Tel: 01903 737756
Email: planning@arun.gov.uk
www.arun.gov.uk/planning
Please ask for: Amy Anderson
Email: amy.anderson@terraquest.co.uk
Telephone: 0121 234 1390
Our Ref: BR/171/25/HH
Your Ref:
Date: 7th October 2025

Application for Planning Permission for Works or Extension to a Dwelling

Development: Single storey rear extension and single storey porch extension.
Location: 17 Annandale Avenue Bognor Regis PO21 2ES

Proposed Site and Block
Plan

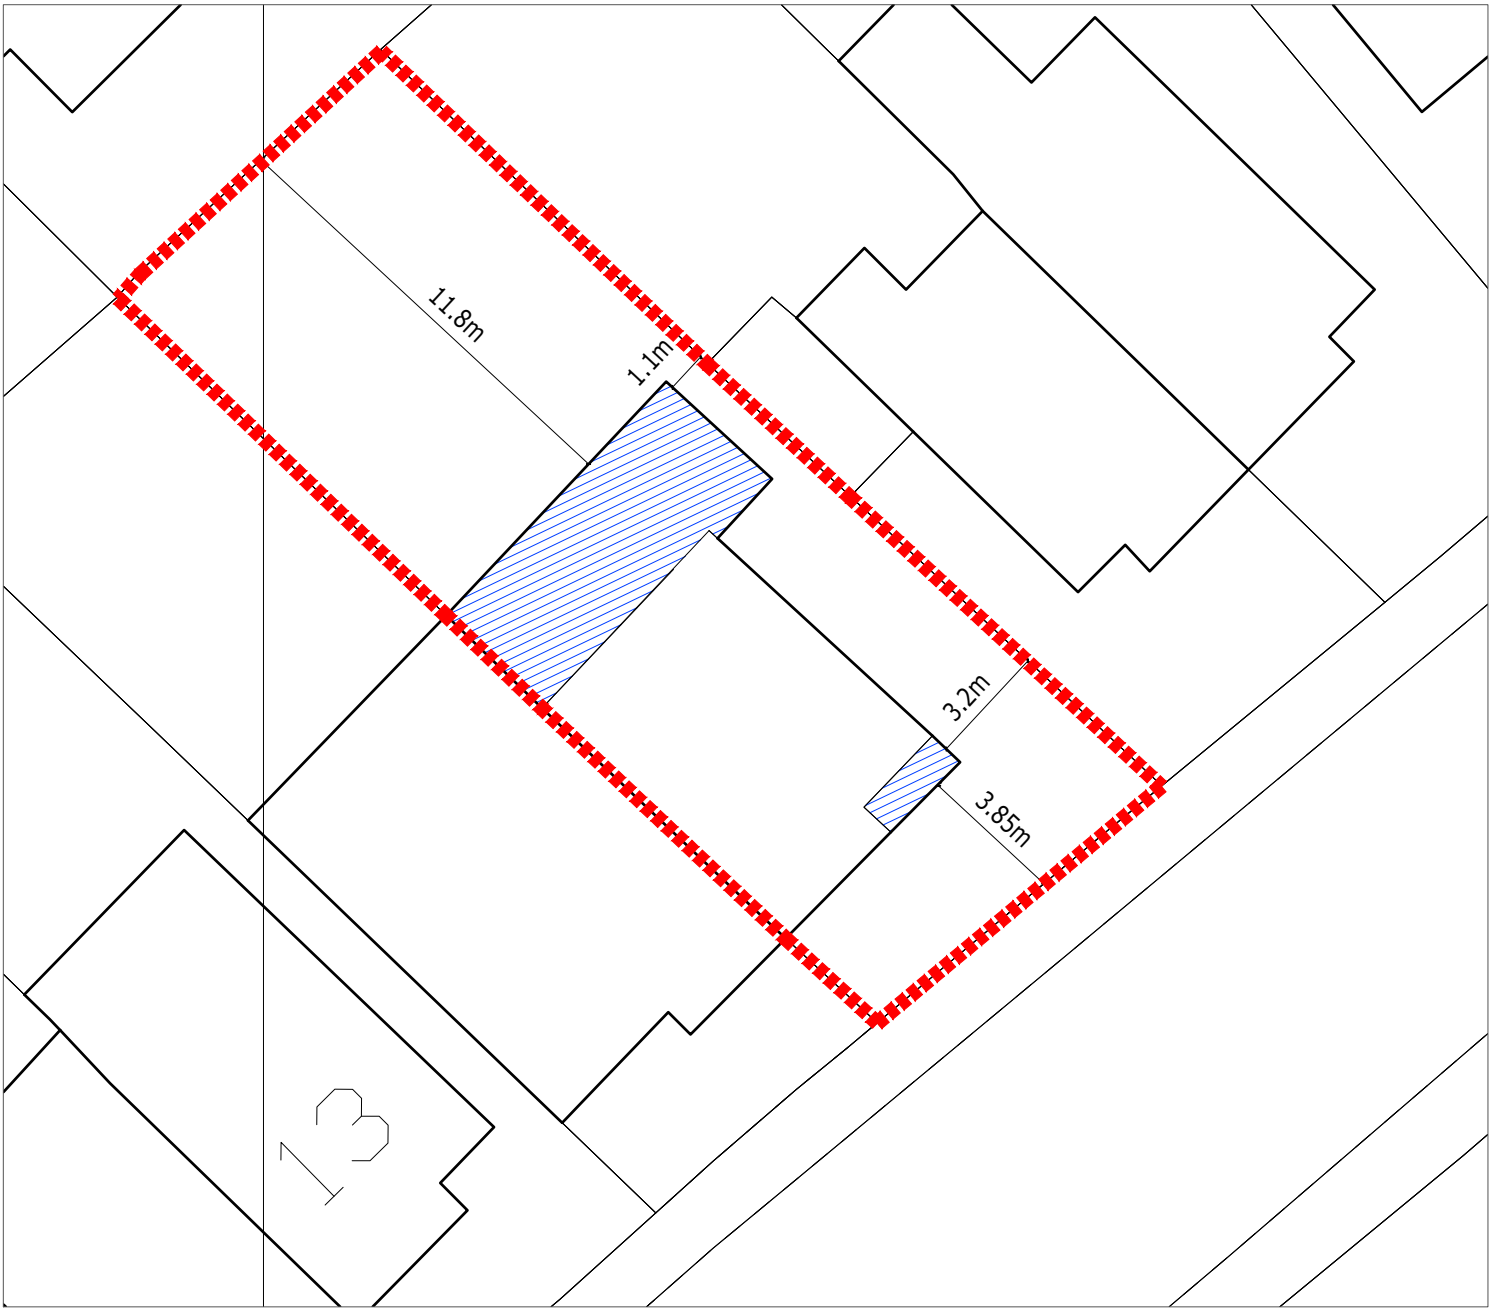
Block Plan

Please ensure that the dimensions from your proposed extensions to the site boundaries are labelled.

Existing Roof Plan_ 1:100

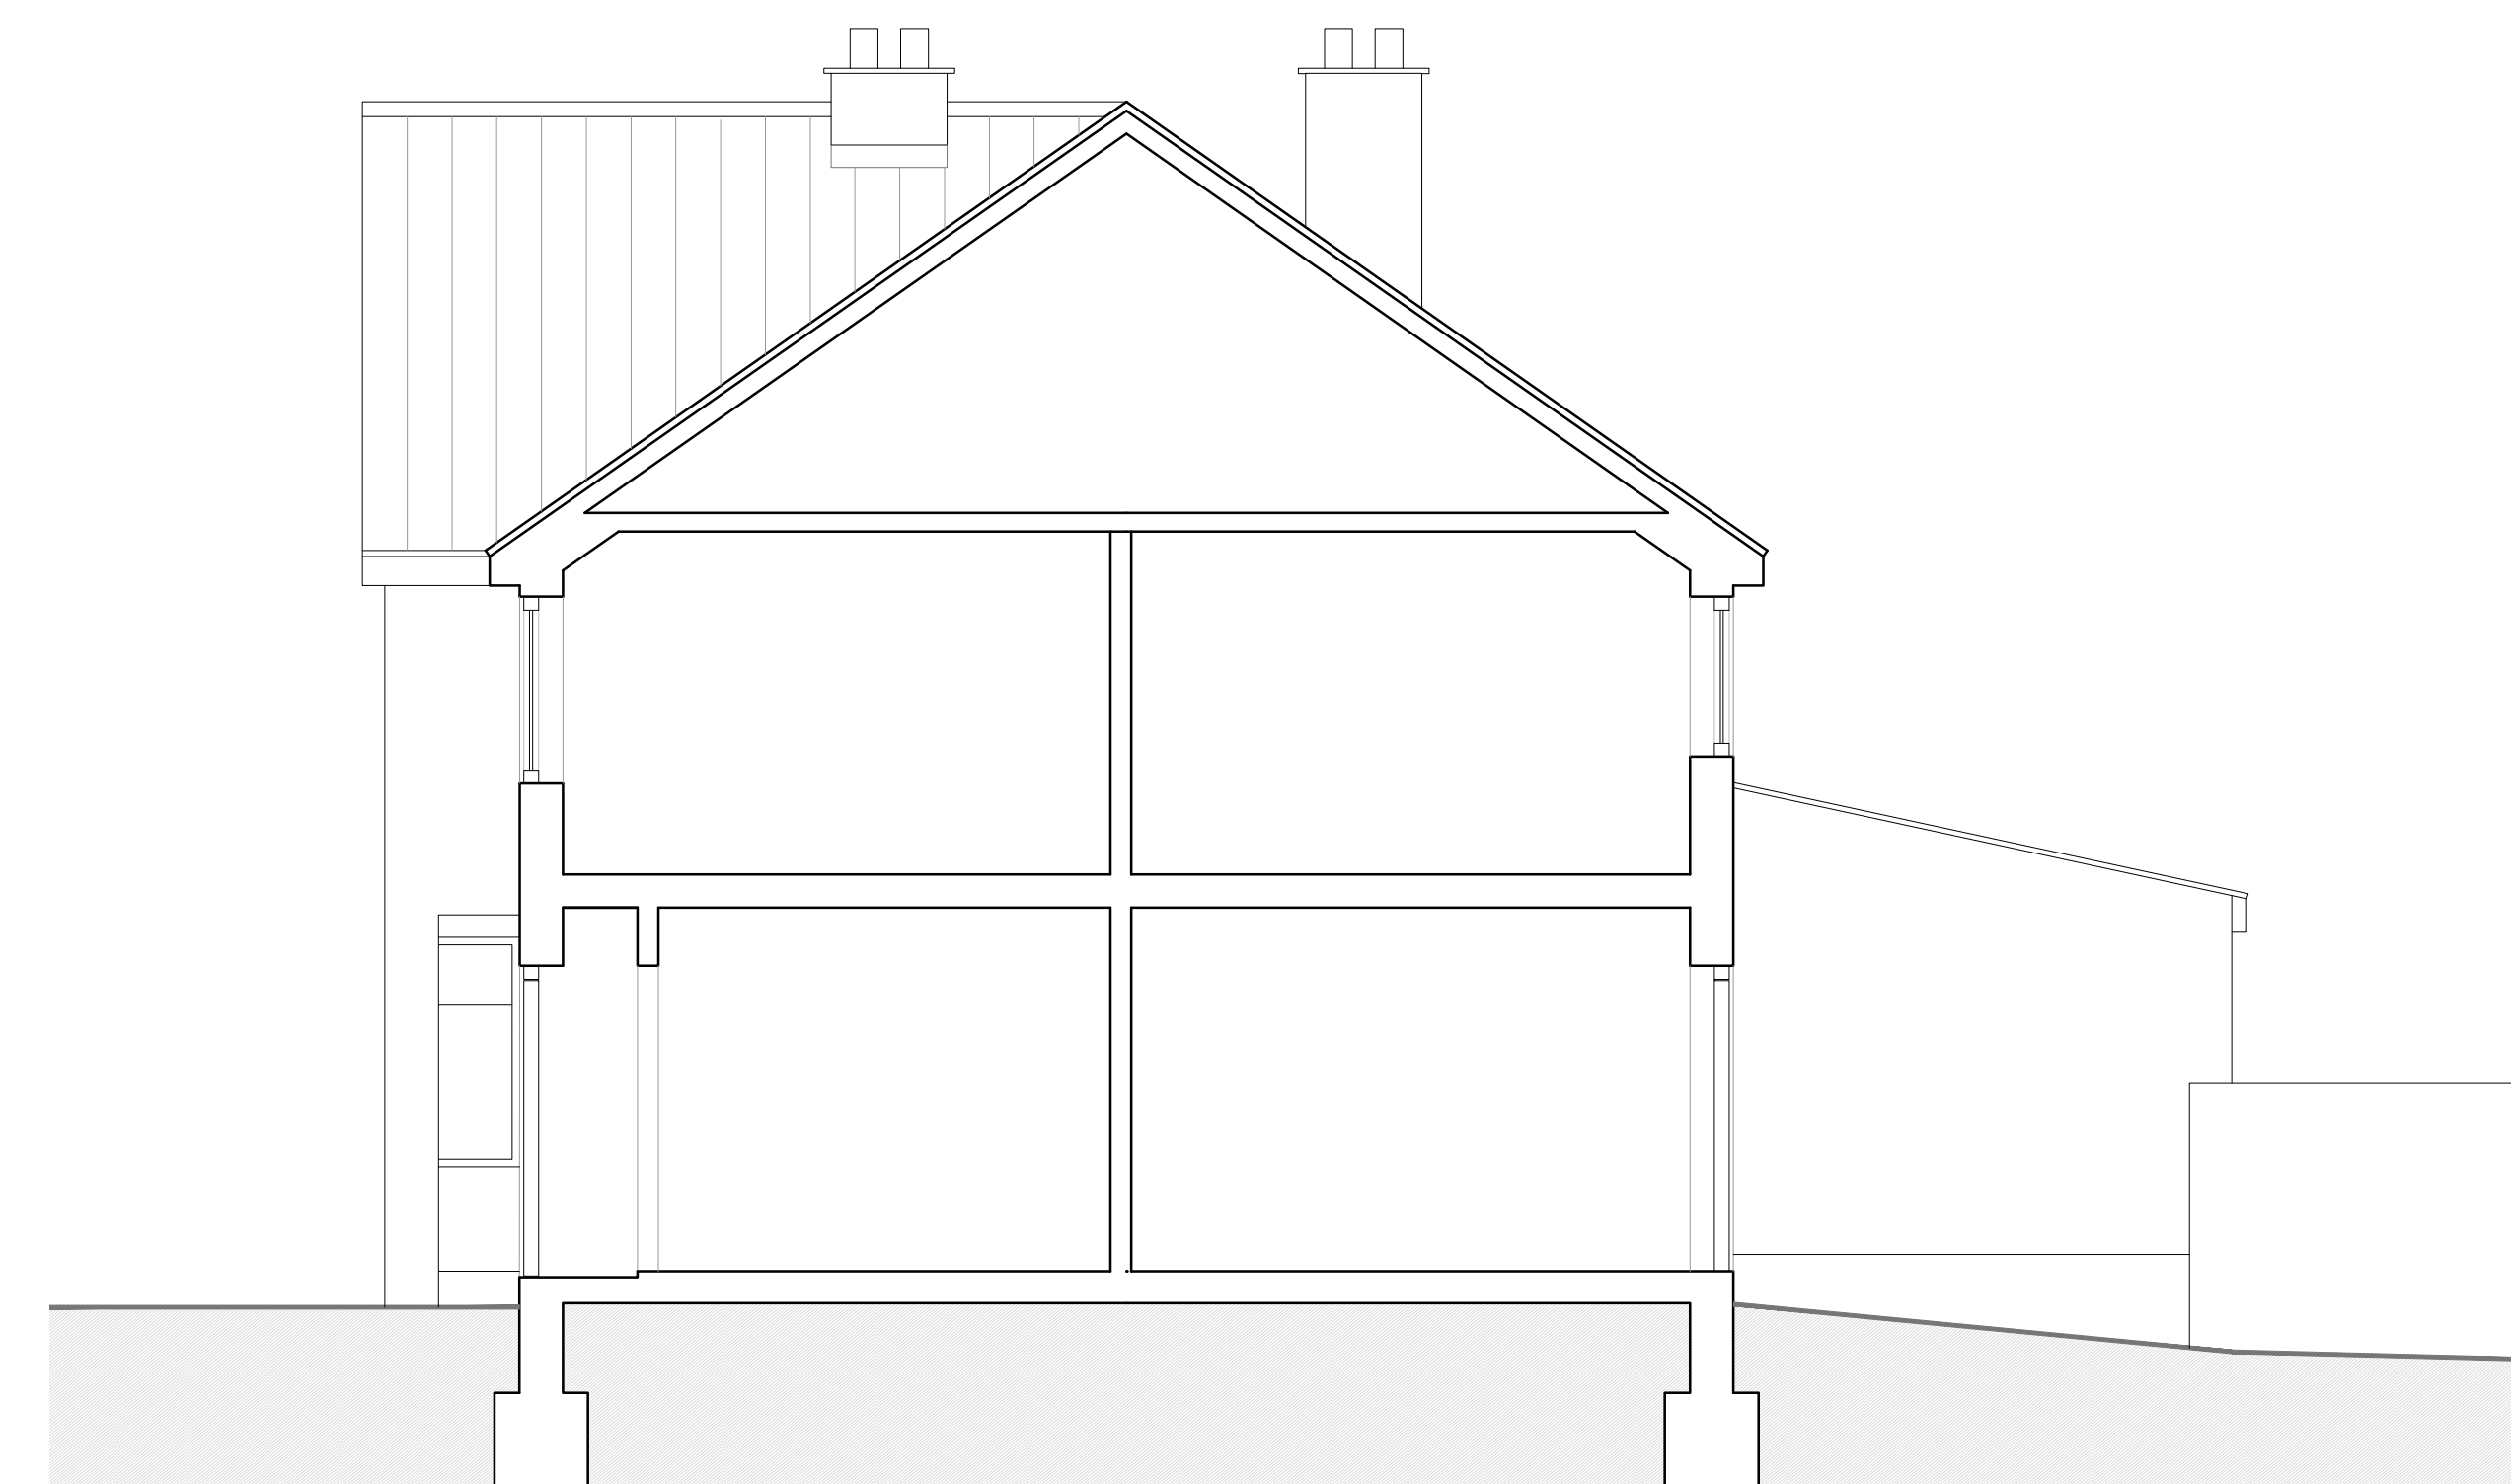
Roof Plan

Please submit electronic plans showing the existing and proposed roof plan. Please refer to the Validation Requirements List for further details.
